## Development & Commercial Stormwater Construction Site Inspection Report

General Information			
Project Name	Buglo Apartments		
Owners/Operators Name	Sharif Rabadi / Mohammad Tahat		
Date of Inspection	6/25/2021	Start Time	8:00 am
Inspector's Name(s)	Mohammad Tahat		
Inspector's Title(s)	Inspector / Self inspection		
Inspector's Contact Information	5756500380		
Inspector's Qualifications			
<b>Type of Inspection:</b> <input checked="" type="checkbox"/> Regular <input type="checkbox"/> During storm event <input type="checkbox"/> Post-storm event			
Weather Information			
Has there been a storm event since the last inspection? NO If yes, provide: Storm Start Date:                      Approximate Amount of Precipitation (in):			
<b>Weather at time of this inspection?</b> <input checked="" type="checkbox"/> Clear <input type="checkbox"/> Cloudy <input type="checkbox"/> Rain <input type="checkbox"/> Sleet <input type="checkbox"/> Snowing <input type="checkbox"/> High Winds <input type="checkbox"/> Partly Cloudy <input type="checkbox"/> Other:

TEMPORARY EROSION AND SEDIMENT CONTROL PLAN

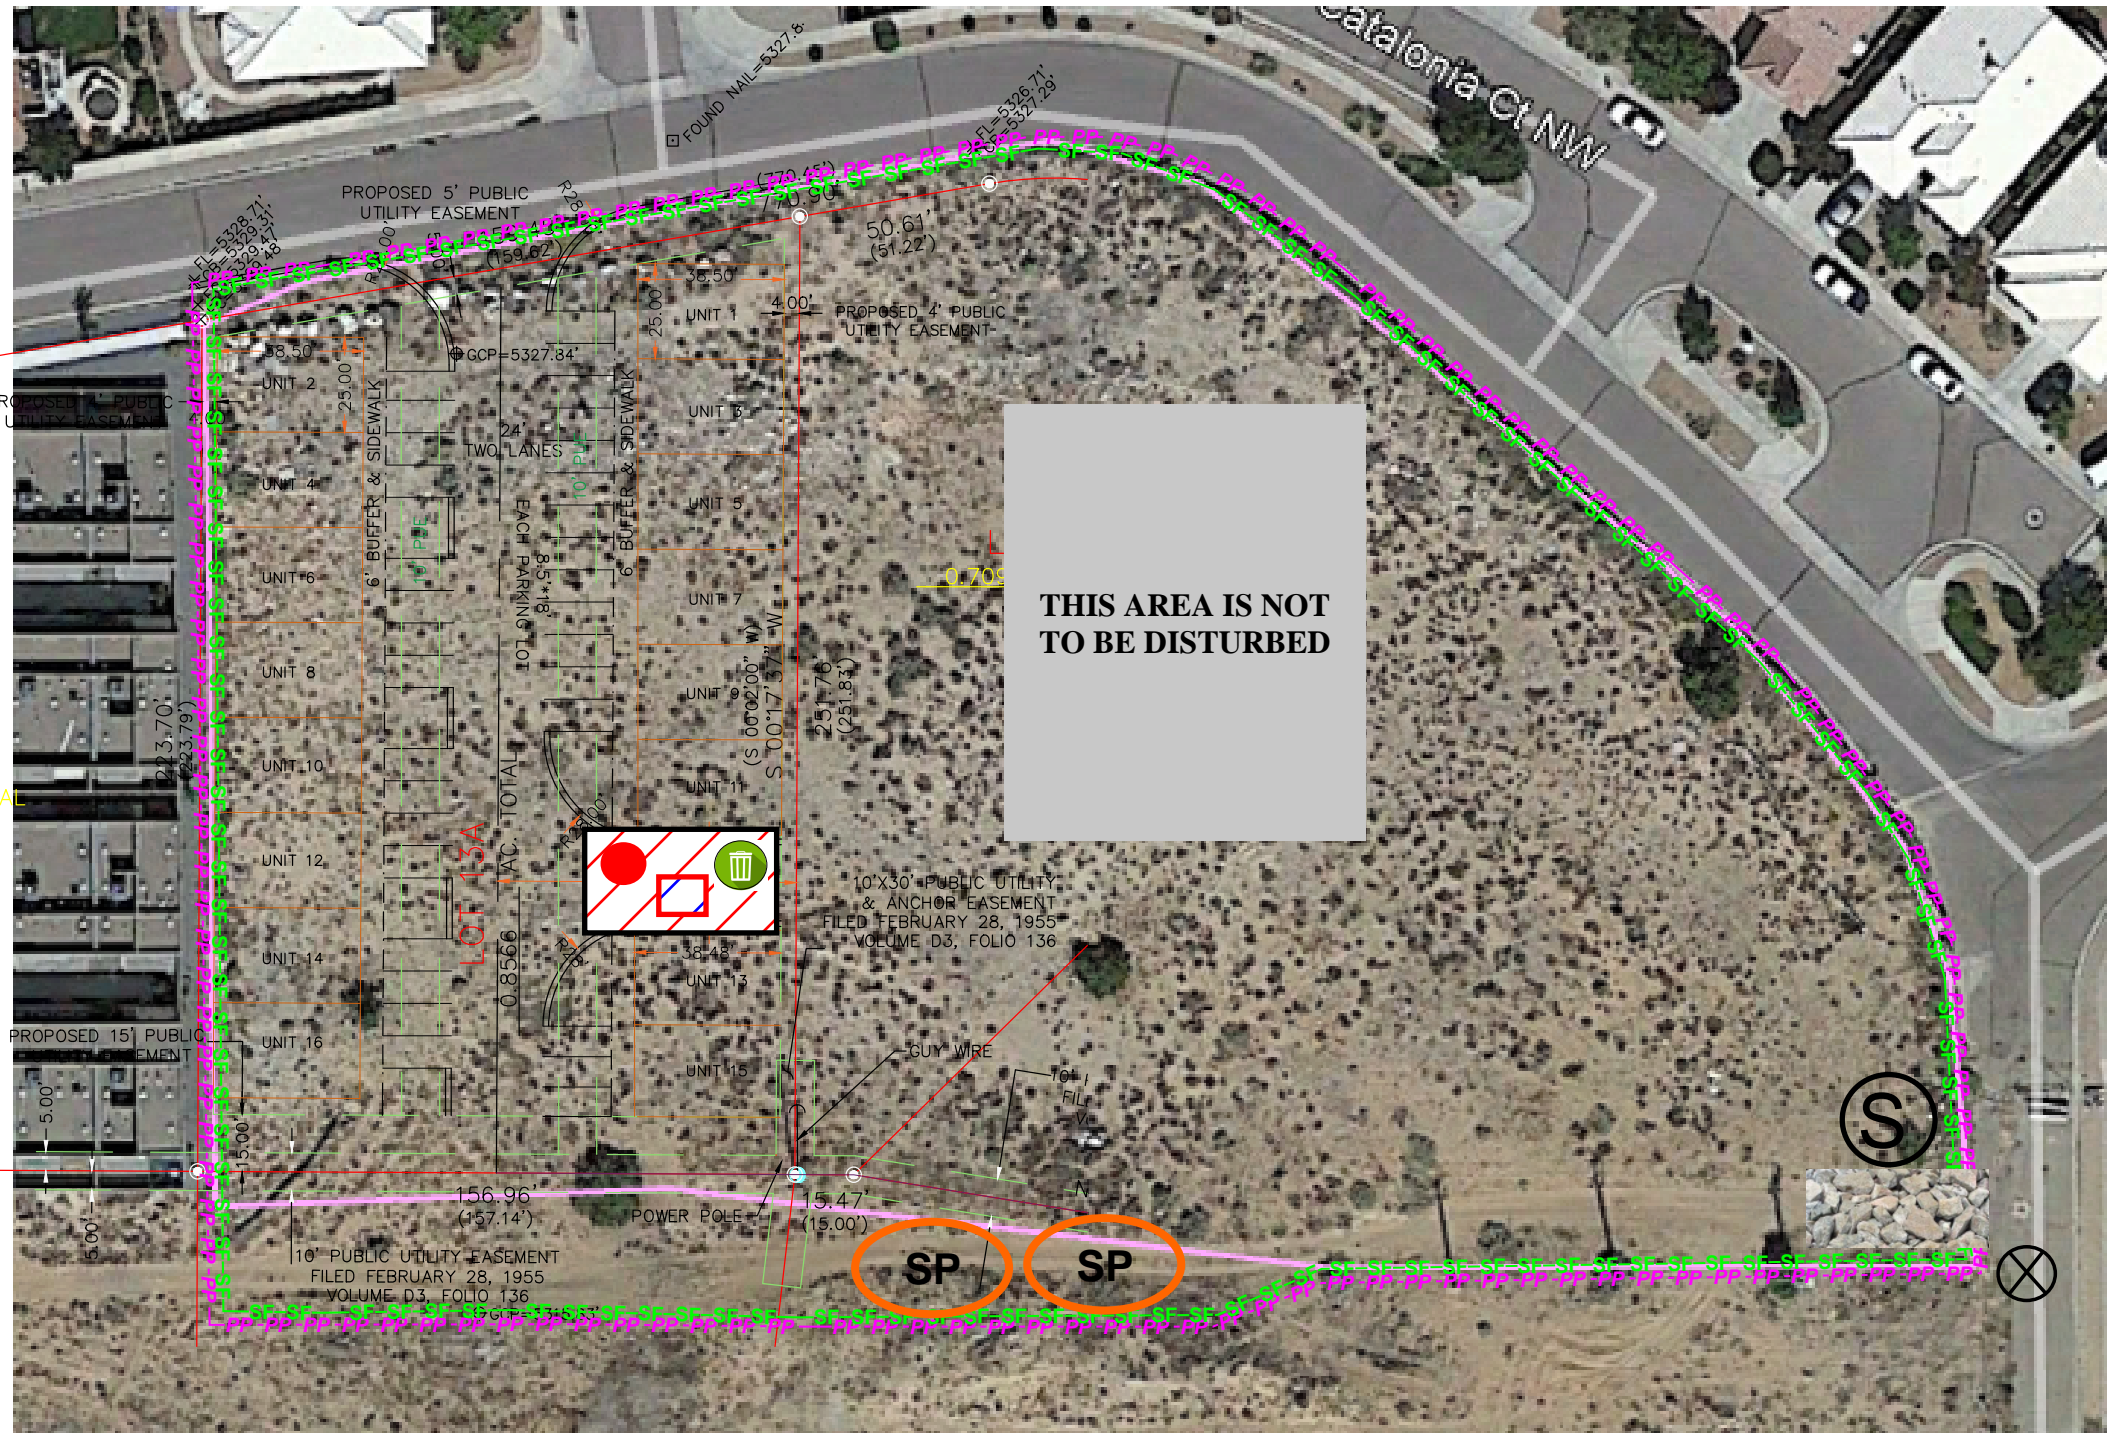
Notes			
1. The fence on the south boundayneed to be changed on the map to match current location because it more appropriate.			
2.			
3.

1	Are the BMPs shown on the map?	yes	
2	Were there changes to the SWPPP?	yes	the fence on the south should be changed on the map
3	Has the SWPPP been updated?	NO	Inspection Plus is working on it
4	Were the changes to the SWPPP implemented within 7 days?	yes
